Longfield Solar Farm

Braintree District Council

Unique Reference: LOSF – 0003

ExQ1 - Responses to Written Questions

Figure 1: Monitoring Locations for NM1, NM2 & NM3 (background image © Google 2021)

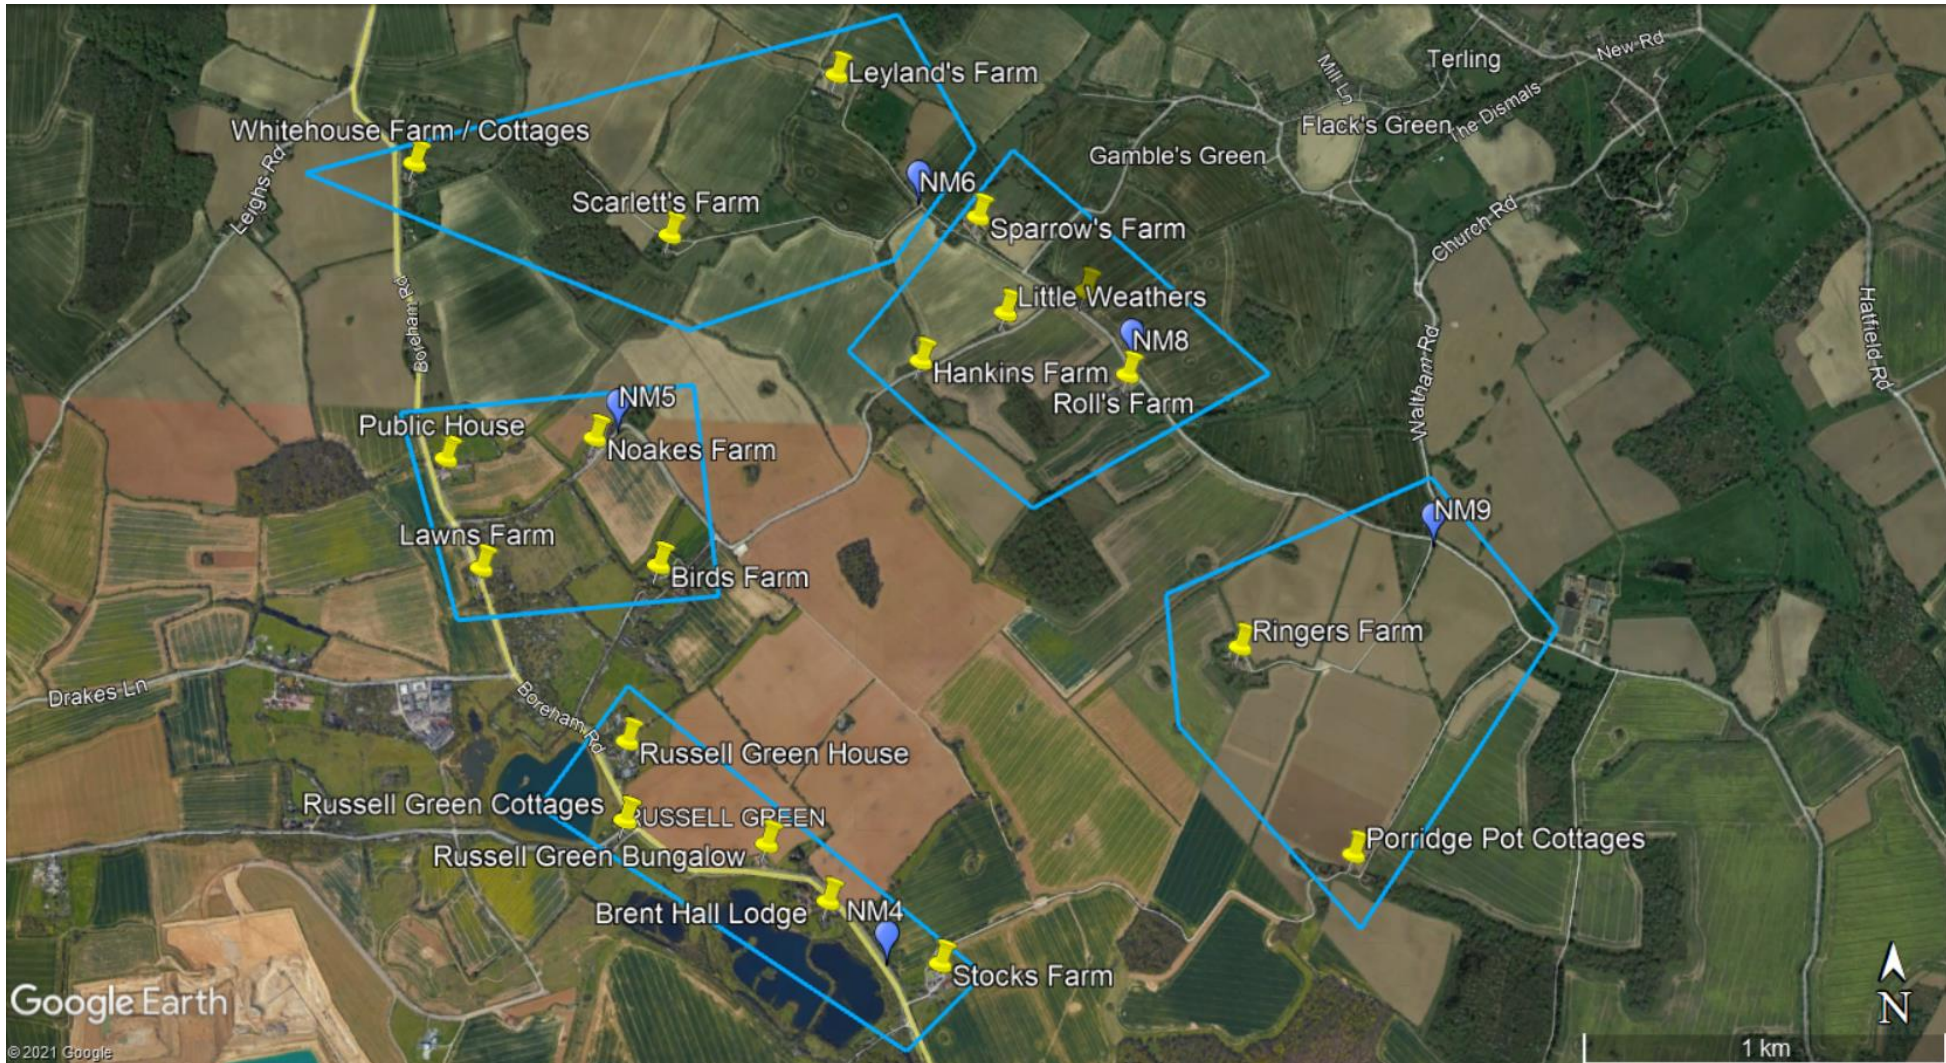
control/prevention would be of interest.
1.10.2	Host Authorities	Do the Host Authorities agree that the locations set out in Figure 11-1 [APP-187] and Table 11-3 [APP-043] are representative of the nearest NSR's?	BDC accepts the monitoring locations and the applicants reasoning for those locations relative to the noise sensitive receptors.
